Re: **Roof Truss Modification**
Location: Lot 77 Providence Creek (Fuquay-Varina, NC)
JDS Project No.: RDU2206408
Date of Inspection: 6/27/2022

A representative of JDS Consulting arrived on site to observe the issues reported to us by the client, which are presented, along with our recommendations, in this report.

Hanger List		All Tie Downs H2.5A Unless noted	
5	LUS24	U4	
19	HTU26	M16	
Special Items List			
Misc Material			
MATTAMY HOMES			
ALLEGHENY		Elev:	FRENCH COUNTRY
PROVIDENCE CREEK			
WAKE	NC	Lot:	77
Appwright #

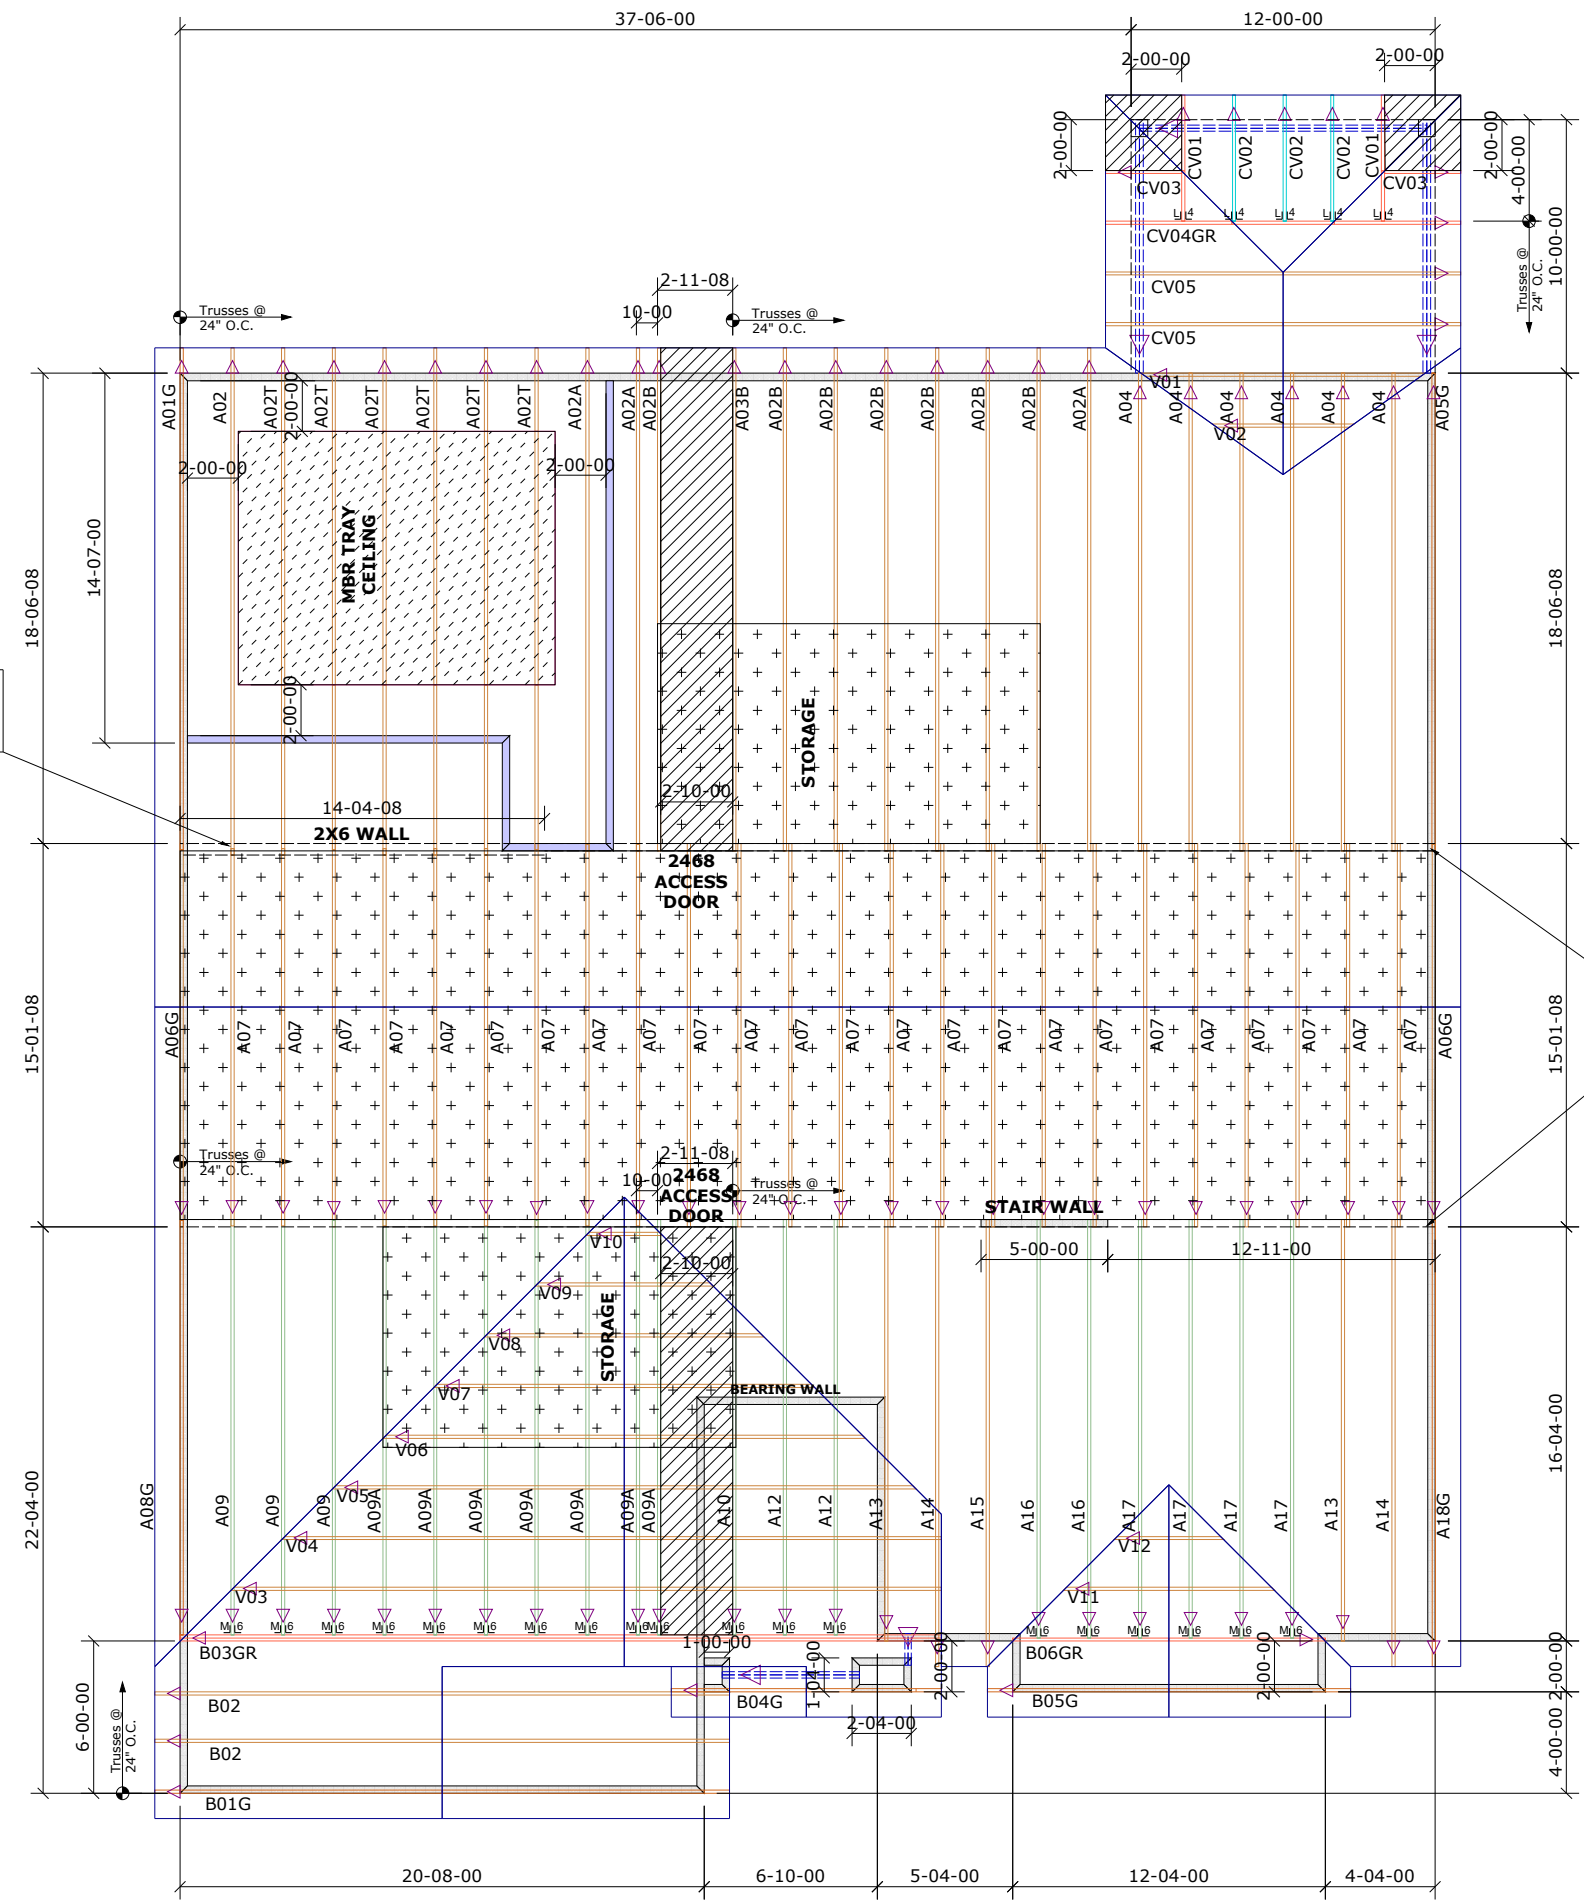
1. The 1st truss from right above the flex room(A14) has been notched starting below joint (6) at the bottom chord. The Notch is 16" in height and 2" in width.

2. The 2nd truss from right above the flex room (A13) has been notched starting at below joint (5) at the bottom chord. The notch is 16" in height and 2" in width.

3. The 3rd truss from right above the flex room (A17) has been notched starting below joint (5) at the bottom chord. The notch is 16" in height and 2" in width.

4. The 4th truss from right above the flex room (A17) has been notched starting below joint (5) at the bottom chord. The notch is 16" in height and 2" in width.

5. The 5th truss from right above the flex room (A17) has been notched starting below joint (5) at the bottom chord. The notch is 16" in height and 2" in width.

6. The 6th truss from right above the flex room (A17) has been notched starting below joint (5) at the bottom chord. The notch is 16" in height and 2" in width.

1. Add a new vertical member in the plane of the truss. Cut to fit tightly between the bottom chord and the diagonal member connecting at joint 11 and abut to notched member. Then, add a 16" x 16" by 7/16" OSB gusset on both sides of joint 11 and bottom chord where the new member has been added. Attach with construction adhesive and (2) rows of 8d nails into each covered member spaced 6" O.C.
2. Add a new vertical member in the plane of the truss. Cut to fit tightly between the bottom chord and the diagonal member connecting at joint 10 and abut to notched member. Then, add a 16" x 16" by 7/16" OSB gusset on both sides of joint 10 and bottom chord where the new member has been added. Attach with construction adhesive and (2) rows of 8d nails into each covered member spaced 6" O.C.

3. For the (4) A17 trusses referenced. Add a new vertical member in the plane of the truss. Cut to fit tightly between the bottom chord and the diagonal member connecting at joint 10 and abut to the notched member. Then, add a 16" x 16" by 7/16" OSB gusset on both sides of joint 10 and bottom chord where the new

member has been added. Attach with construction adhesive and (2) rows of 8d nails into each covered member spaced 6" O.C.
